2023/1001

9 Stevenson Drive, Higham, Barnsley, S75 1PA

Re-modernisation of existing bungalow including:

1. Raising of roof to provide first floor accommodation
  2. Side extension works to provide larger additional accommodation
  3. Garage extension
  4. Extensive internal alterations and new window and door alterations
-

Project.	9 STEVENSON DRIVE HIGHAM, BARNSELY, S75-1PA	Client.	C & J BELL
Drawing Title.	PLANNING DRAWING STREET ELEVATIONS AS EXISTING & PROPOSED	Date.	OCT 2023
Ref.	104-104	Dwg. No.	P03
		Scale.	AS INDICATED
		Rev.	C

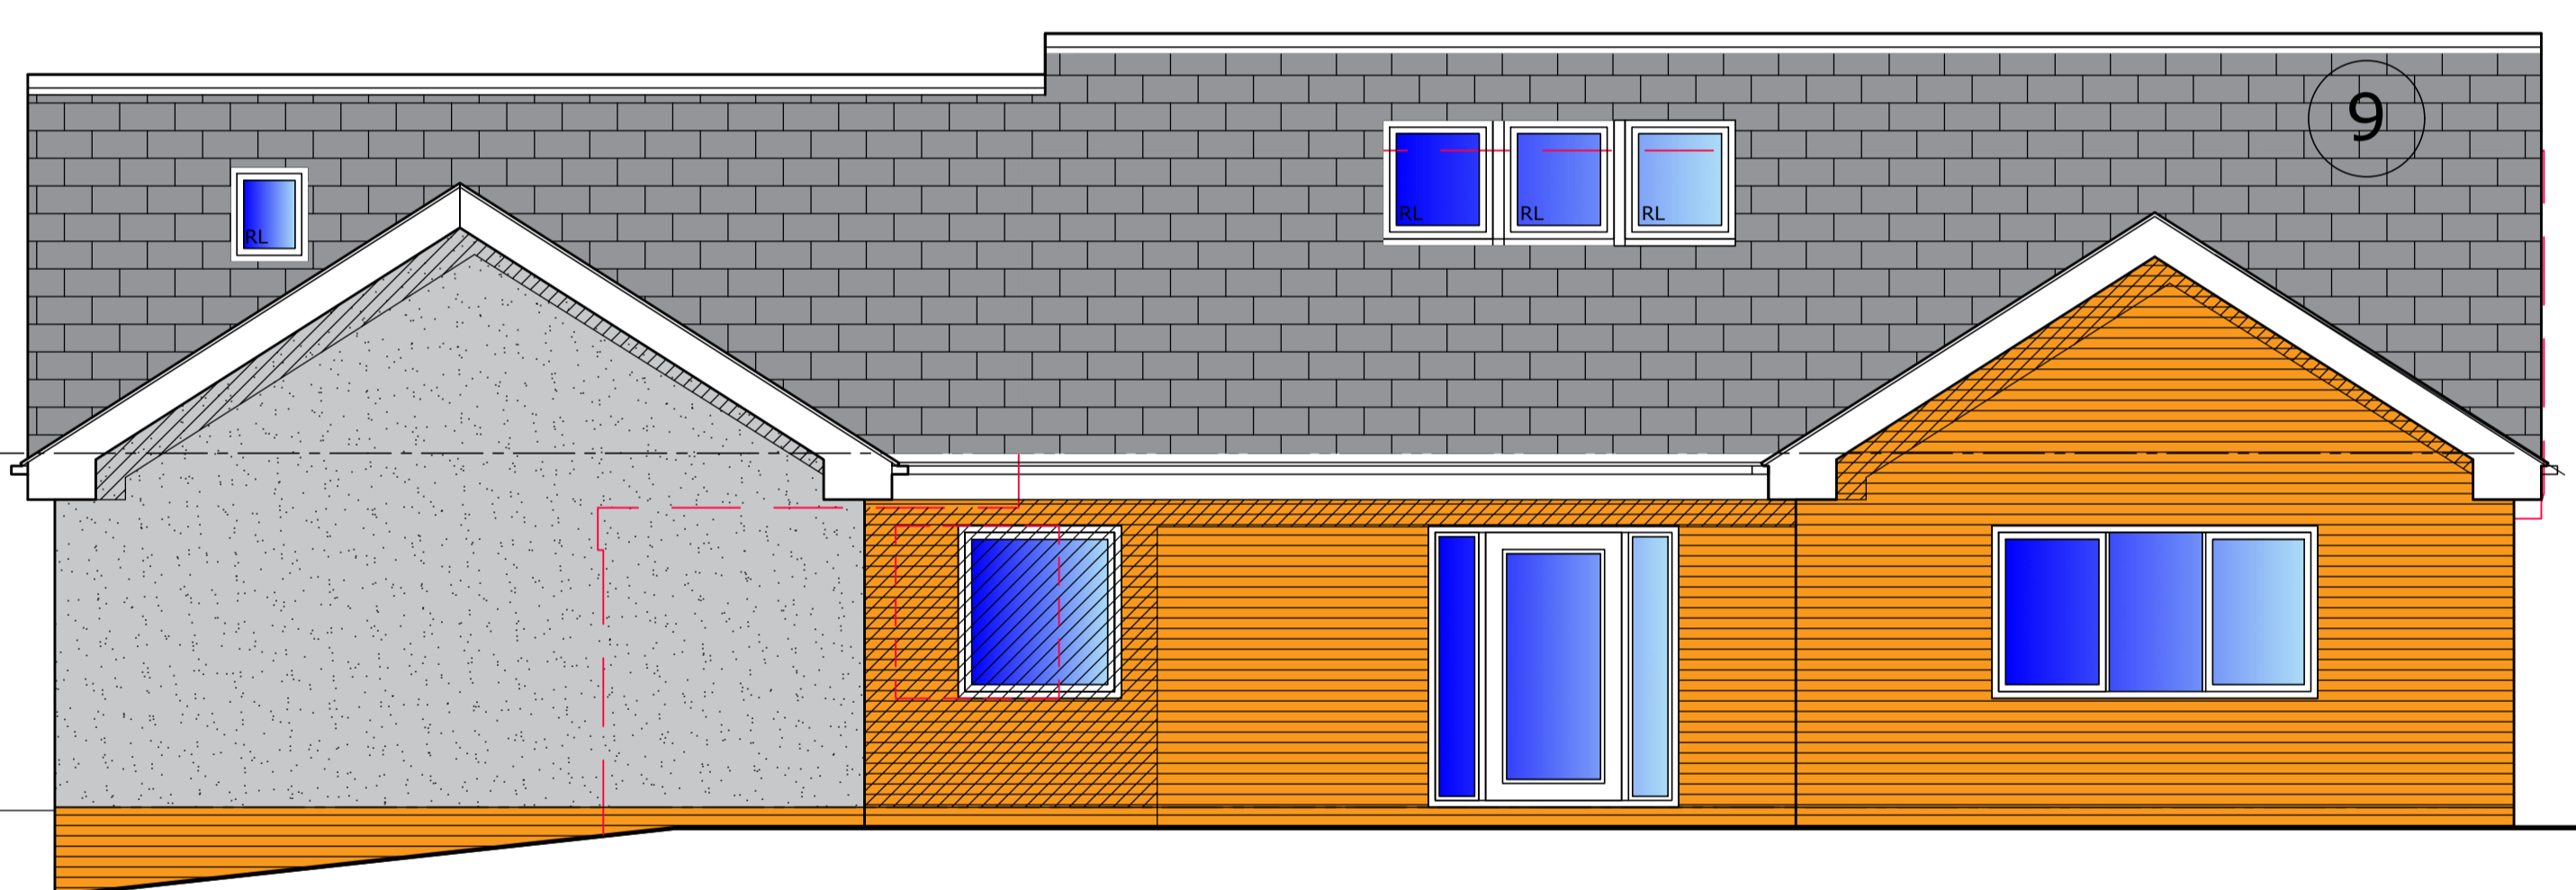
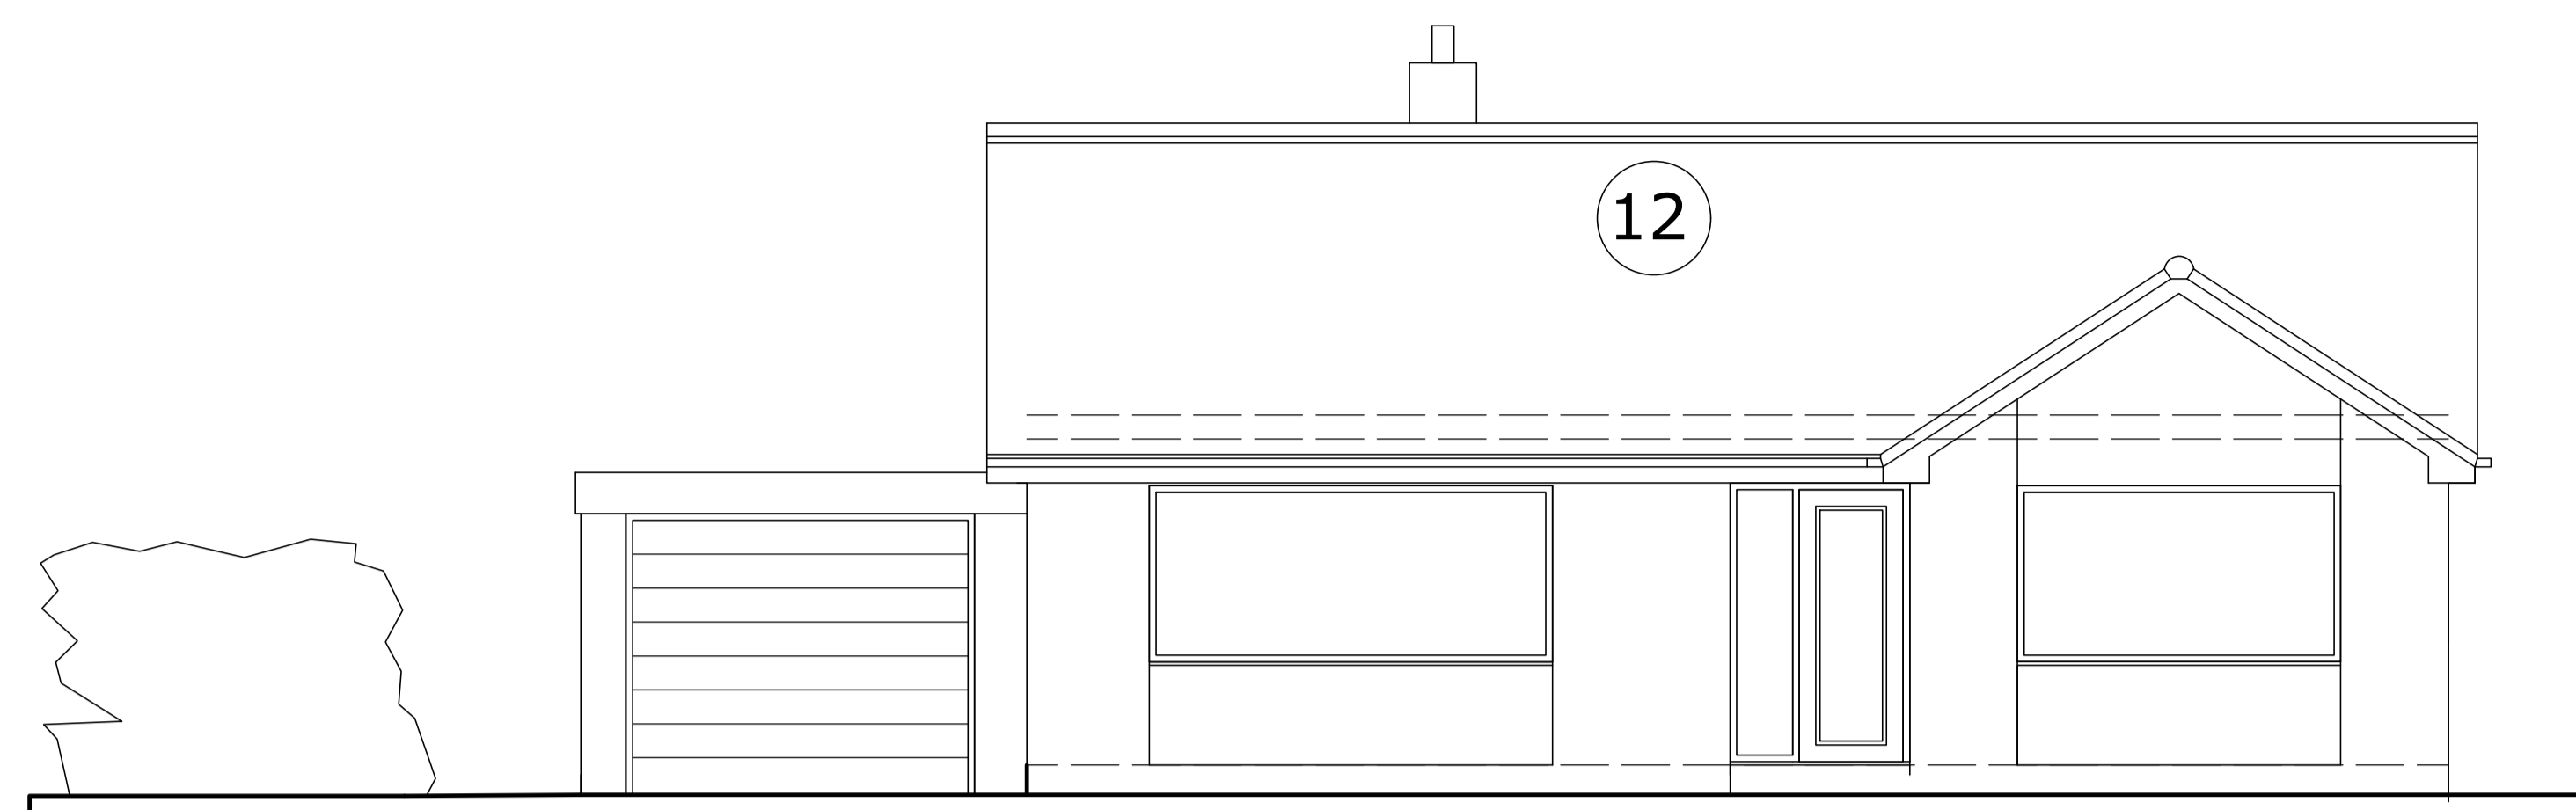
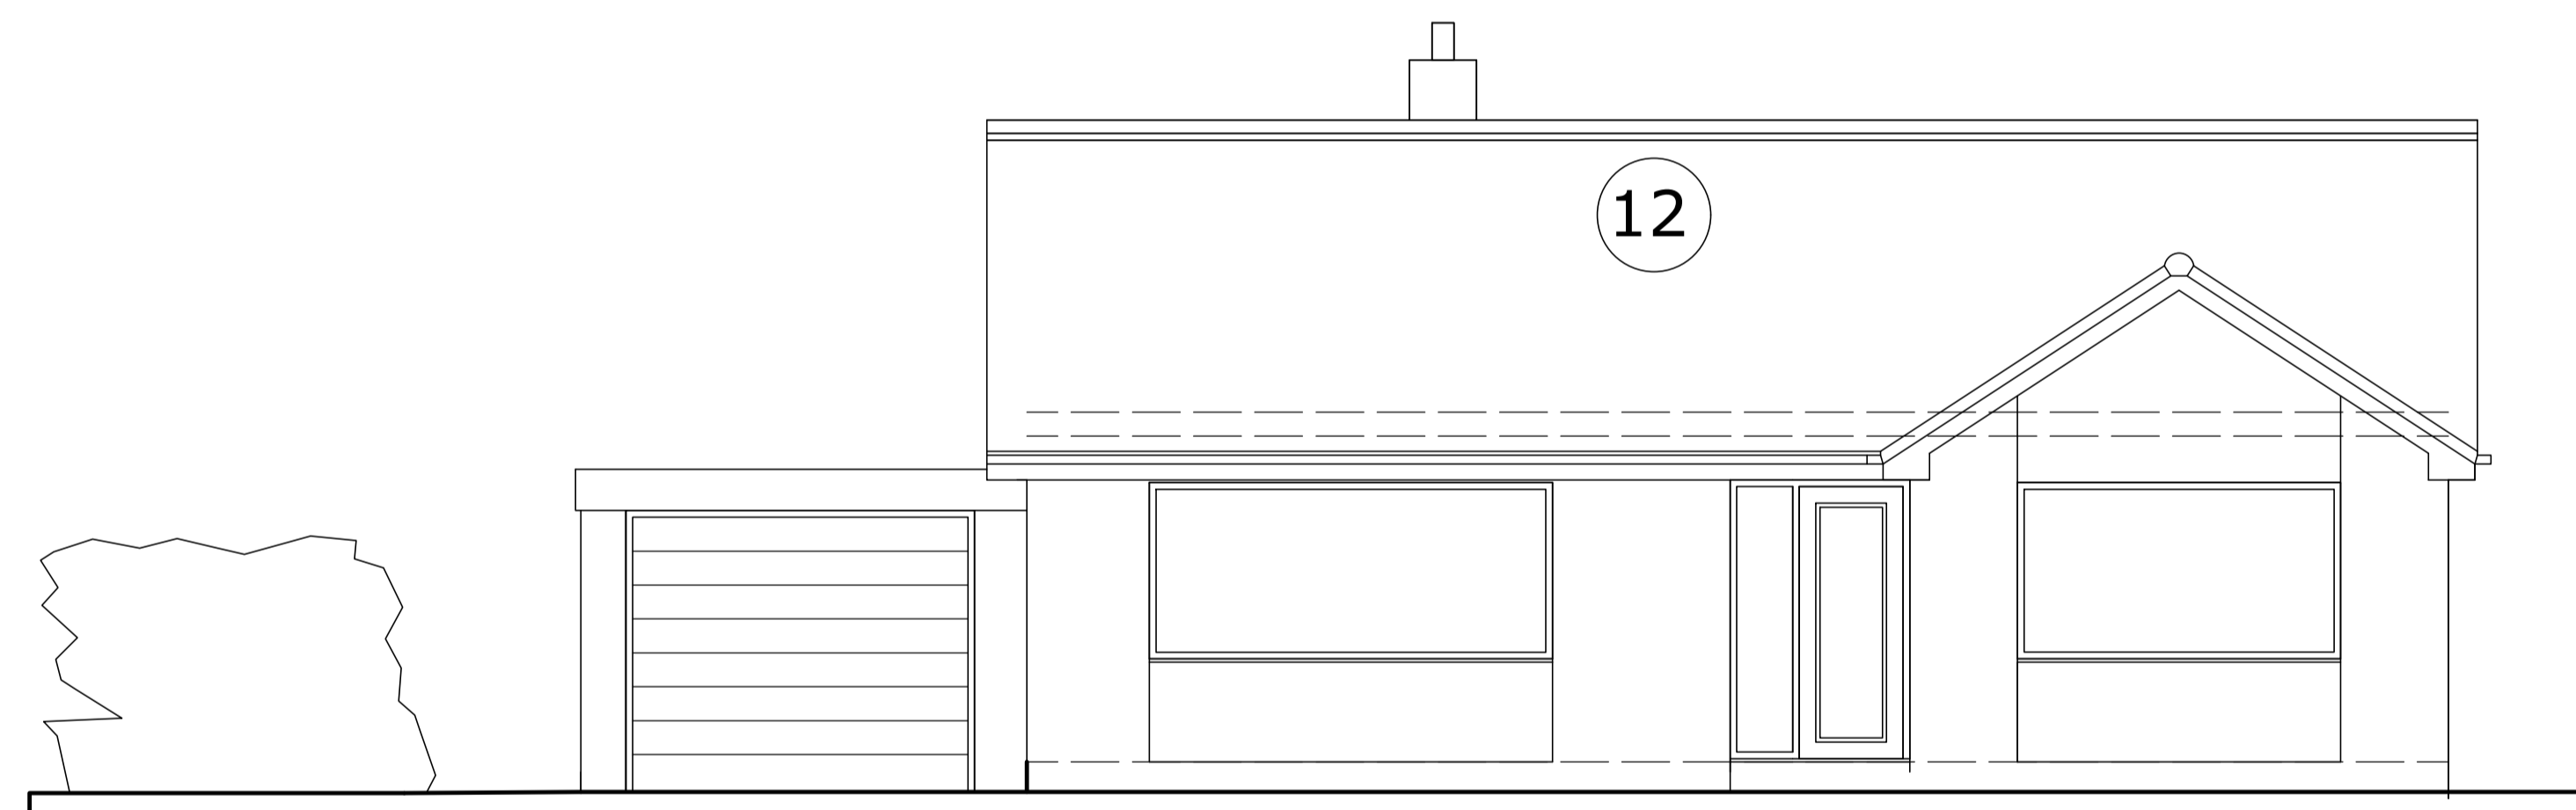
The proposal would be visible from the public realm of Stevenson Drive and would be a prominent feature within the street scene.

The proposed enlargement and alterations to the external appearance of the host dwelling could impact the character of the street scene. Concerns were raised regarding the proposed increase in roof height and the loss of an existing gable element to the front. It was considered that the proposal would have contributed to an unbalanced and overly dominant appearance. However, amendments have since been submitted to include a reduction in roof height, the re-introduction of gable elements to the front and a step down in the ridge line above the extension. The amended proposal is subject to consideration.
